9th June 2011

Change of use from (A1) kiosk to (A3) cafe to include replacing timber boarded front elevation with glazing & fit security shutters to door & window openings. Re-site fryer flue & fix flag & install 2 no. toilets & storage unit at rear
West Beach Cafe Rope Walk Littlehampton

Thank you for your internet representation made on 9th June 2011 which has been recorded as **no objection** with the comments as follows:

PLAN OF PROPOSED W.C.'s AND STORAGE UNIT LOCATED AT WEST BEACH CAFE, LITTLEHAMPTON. BN17 5DE.

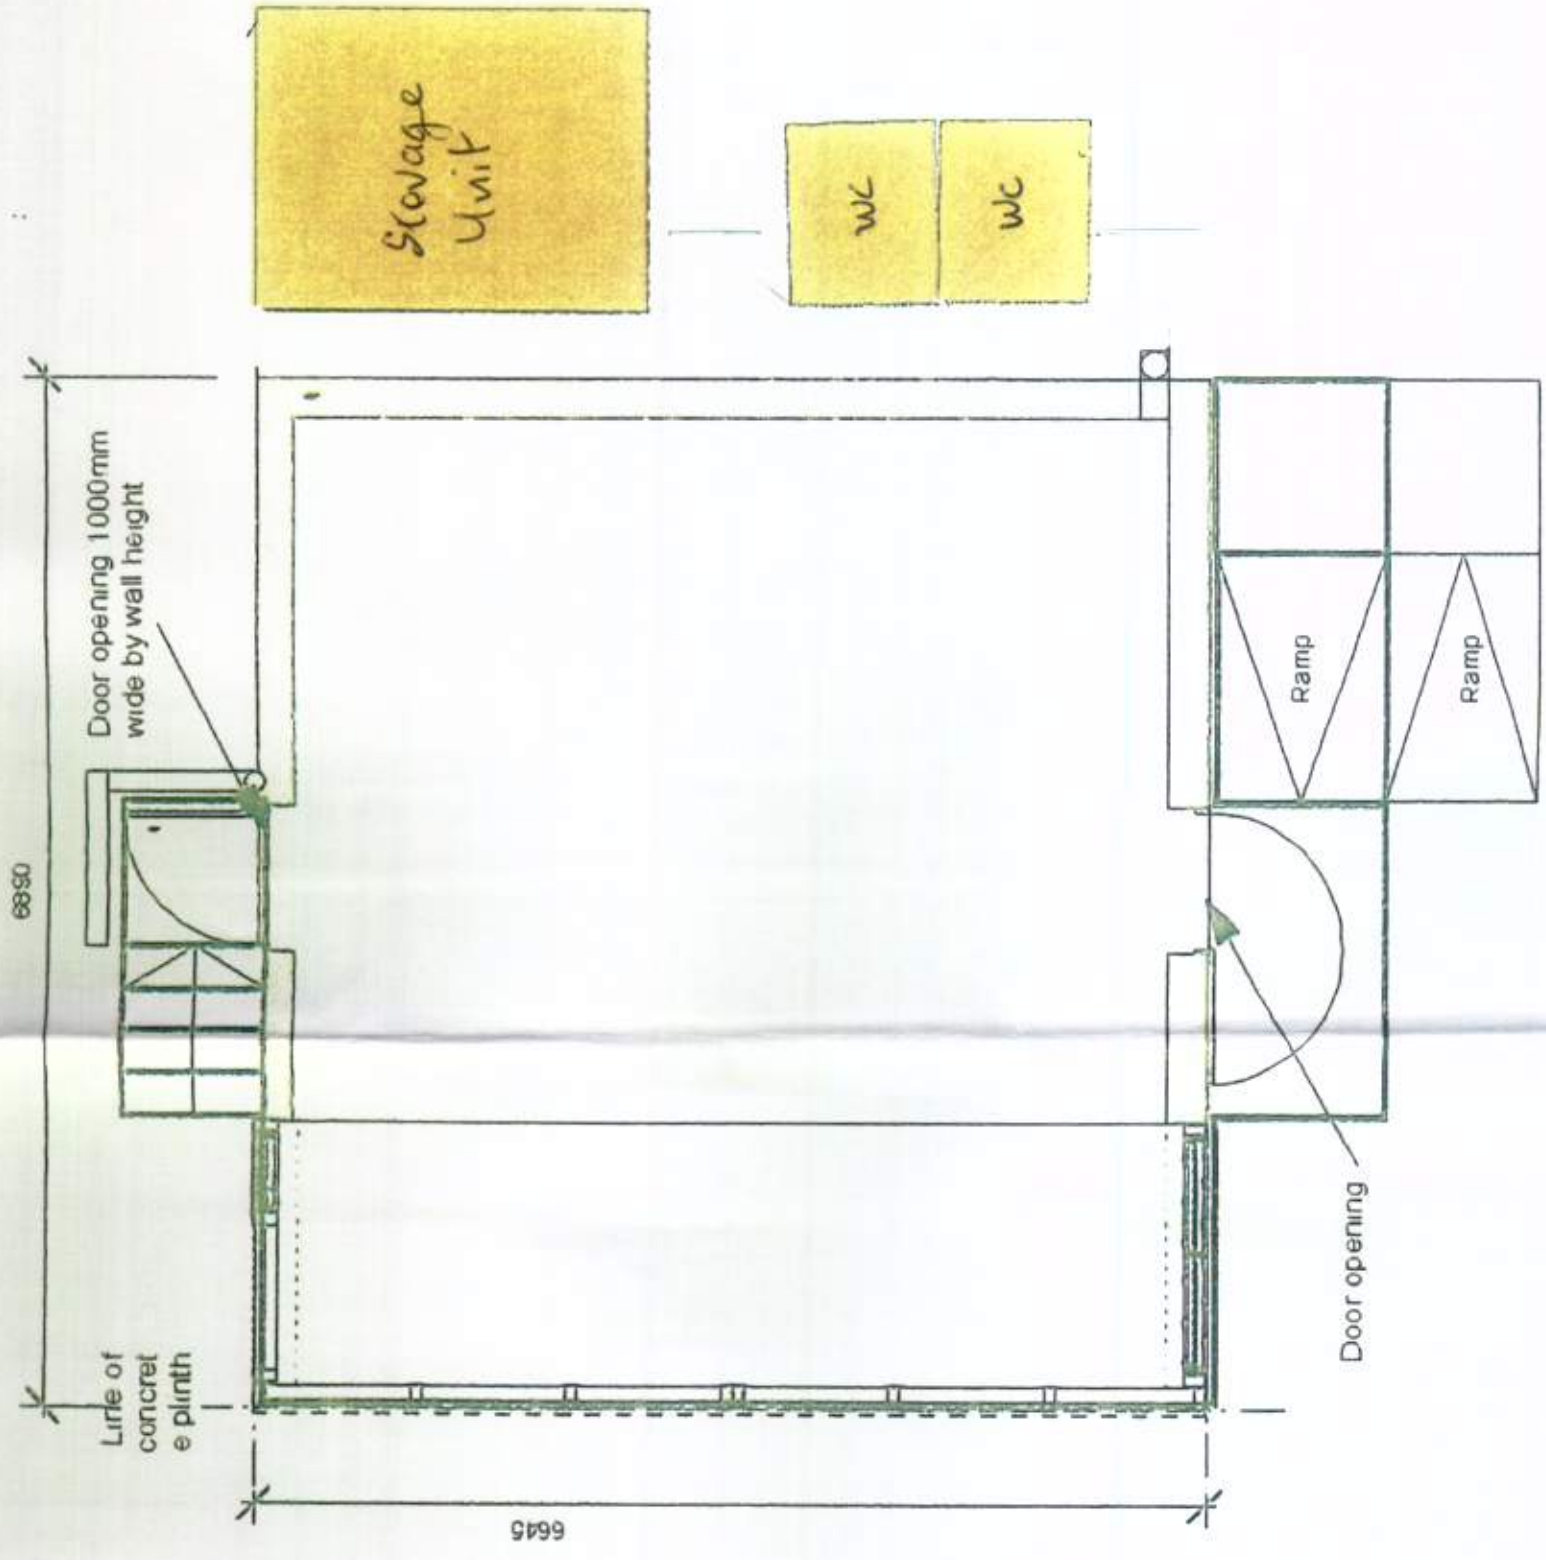
The proposal for the provision of customer sanitary accommodation must comply with all current relevant legislation, in that the toilets must be connected to a suitable and sufficient foul drainage system, are capable of being maintained in a clean condition and hot and cold running water is provided to a wash hand basin within each wc cubicle. The toilets must not open directly into a food room. □

□
The proposed 'storage container' if to be utilised for the storage of foods and food contact equipment, must comply with current food hygiene regulations, in that, the internal surfaces are able to be effectively cleaned & disinfected, adequate means of ventilation is provided where appropriate, lighting is sufficient and pest proofing is achievable given the remote location of this food premises and potential rodent activity in surrounding vegetation and dunes.
